MESA DEL SOL
ARCHITECTURAL CONTROL COMMITTEE
SITE DEVELOPMENT PLAN REVIEW

MESA DEL SOL SELF STORAGE

SITE PLAN

AS-1.0

1 SITE PLAN
1"=30'-0"

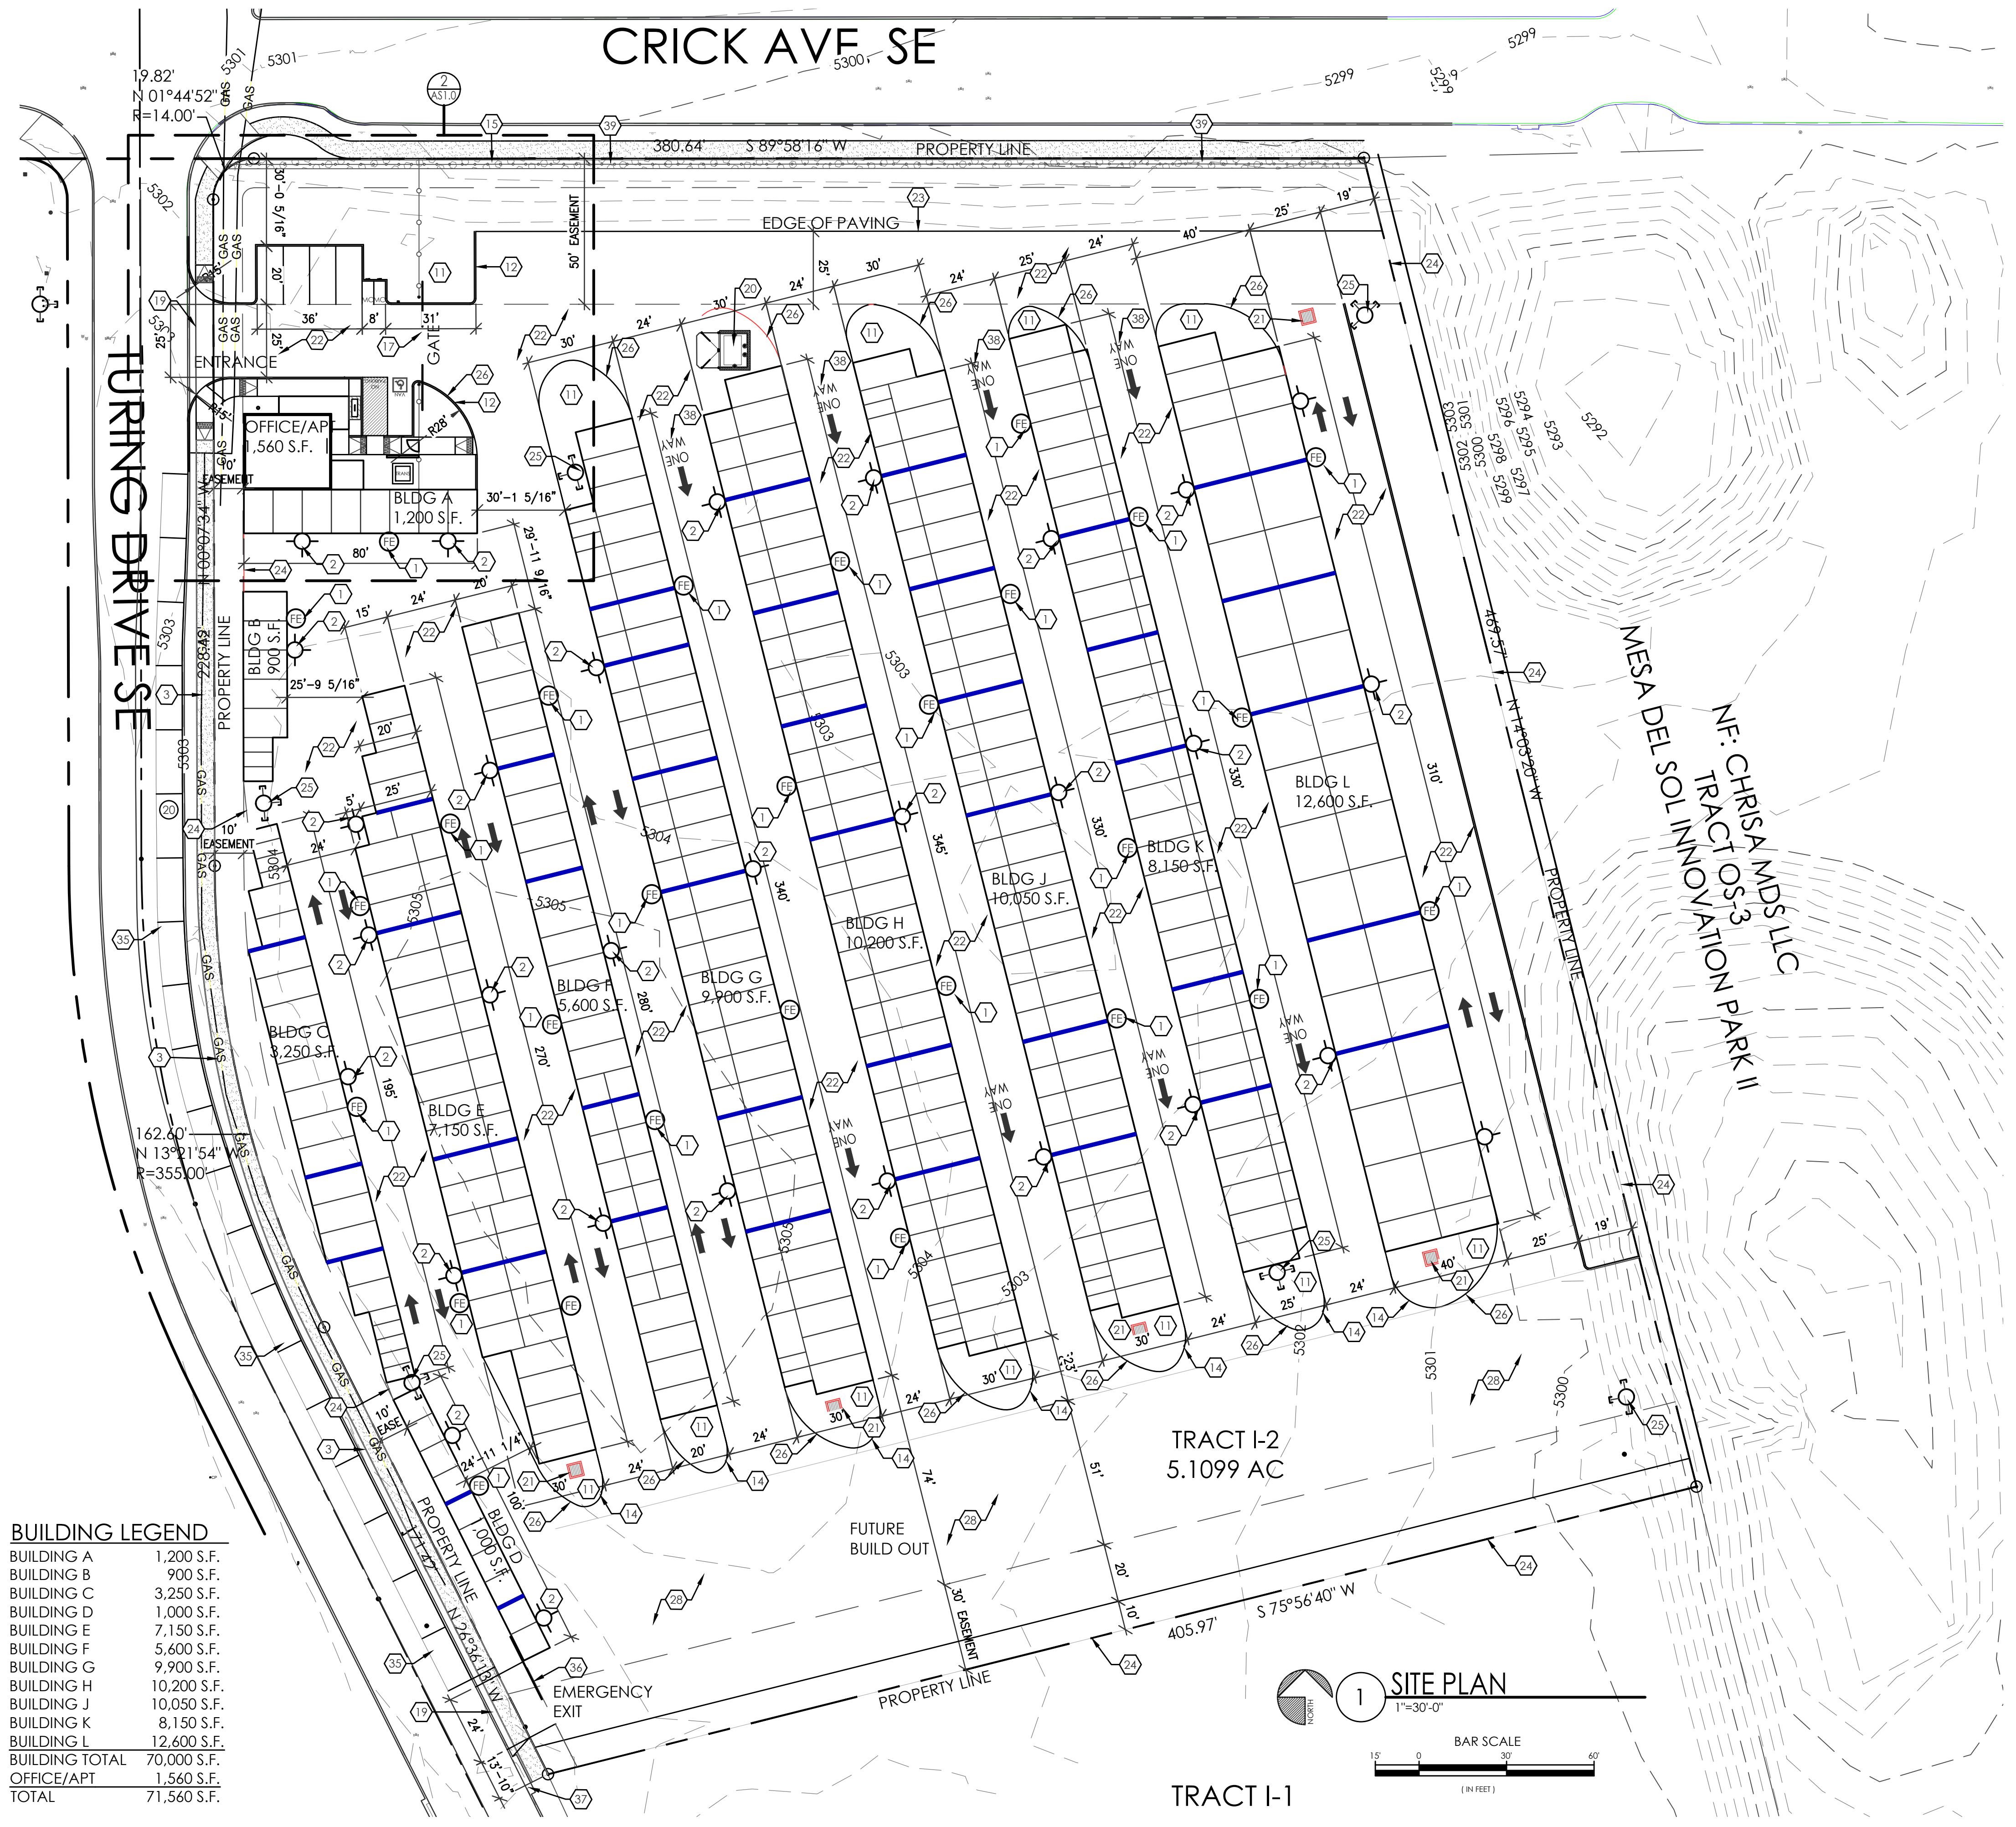
Approved for access by the Solid Waste Department.

All containers must be made accessible for pick up

between the hours of 5AM and 8PM.

Keypad access

Gate will open 25' clear

Recycling declined
